DOC18/35189-01
SSD 8614

SSD 8614 – HURLSTONE AGRICULTURAL HIGH SCHOOL – ENVIRONMENTAL IMPACT STATEMENT (EIS)

SSD 8614 HURLSTONE AGRICULTURAL HIGH SCHOOL

- LEGEND
- EXISTING ROAD
  - NEW ROAD / WIDEN ROAD
  - NEW CARPARK AND BUS STOP EXTENSION
  - NOT PART OF STATE SIGNIFICANT DEVELOPMENT APPLICATION

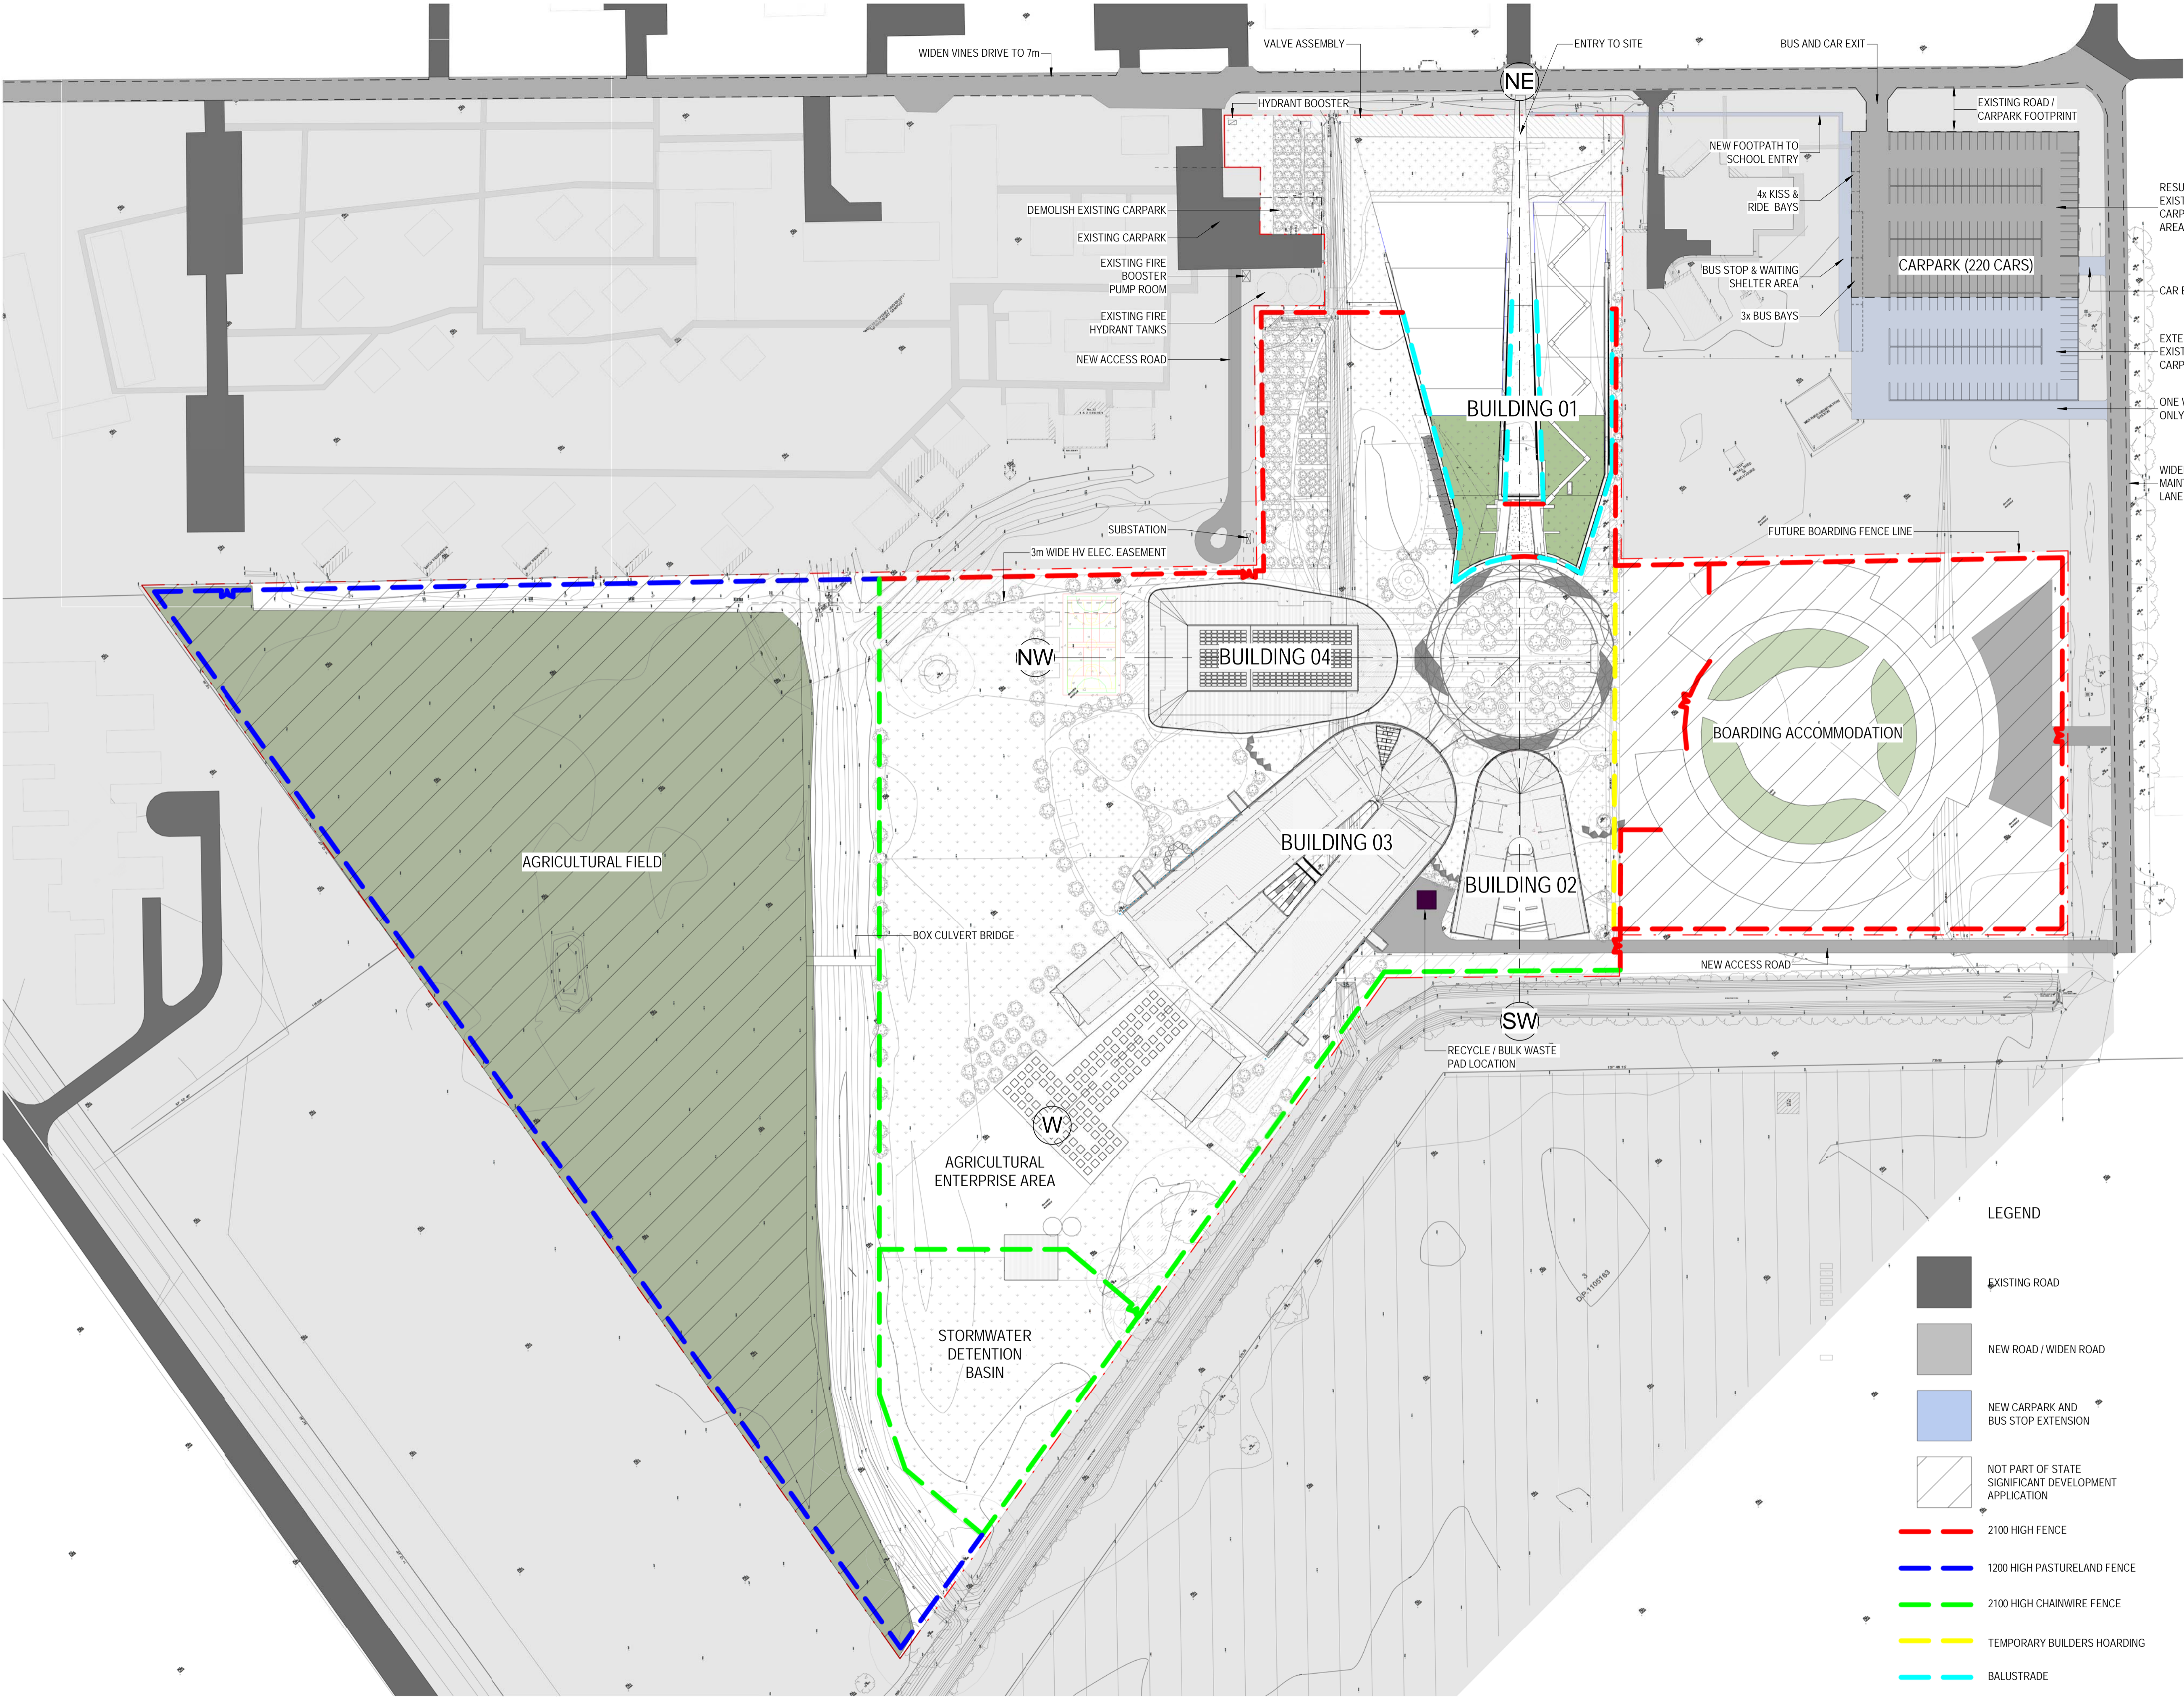
The EIS site plan (i.e. drawing HASH-00-DD-AR-DR-1001 Revision G) indicates areas proposed to be allocated for an 'agricultural field' and 'agricultural enterprise area'. The EPA anticipates –

- (a) the application of fertiliser and pesticides to the agricultural field, and
- (b) that the agricultural enterprise area is likely to be used in part for the keeping of livestock and associated localised deposits of animal wastes in livestock pens and enclosures.

The proponent be required to ensure that runoff from the agricultural field and agricultural enterprise area does not pollute waters, including artificial watercourses such as stormwater drainage channels.
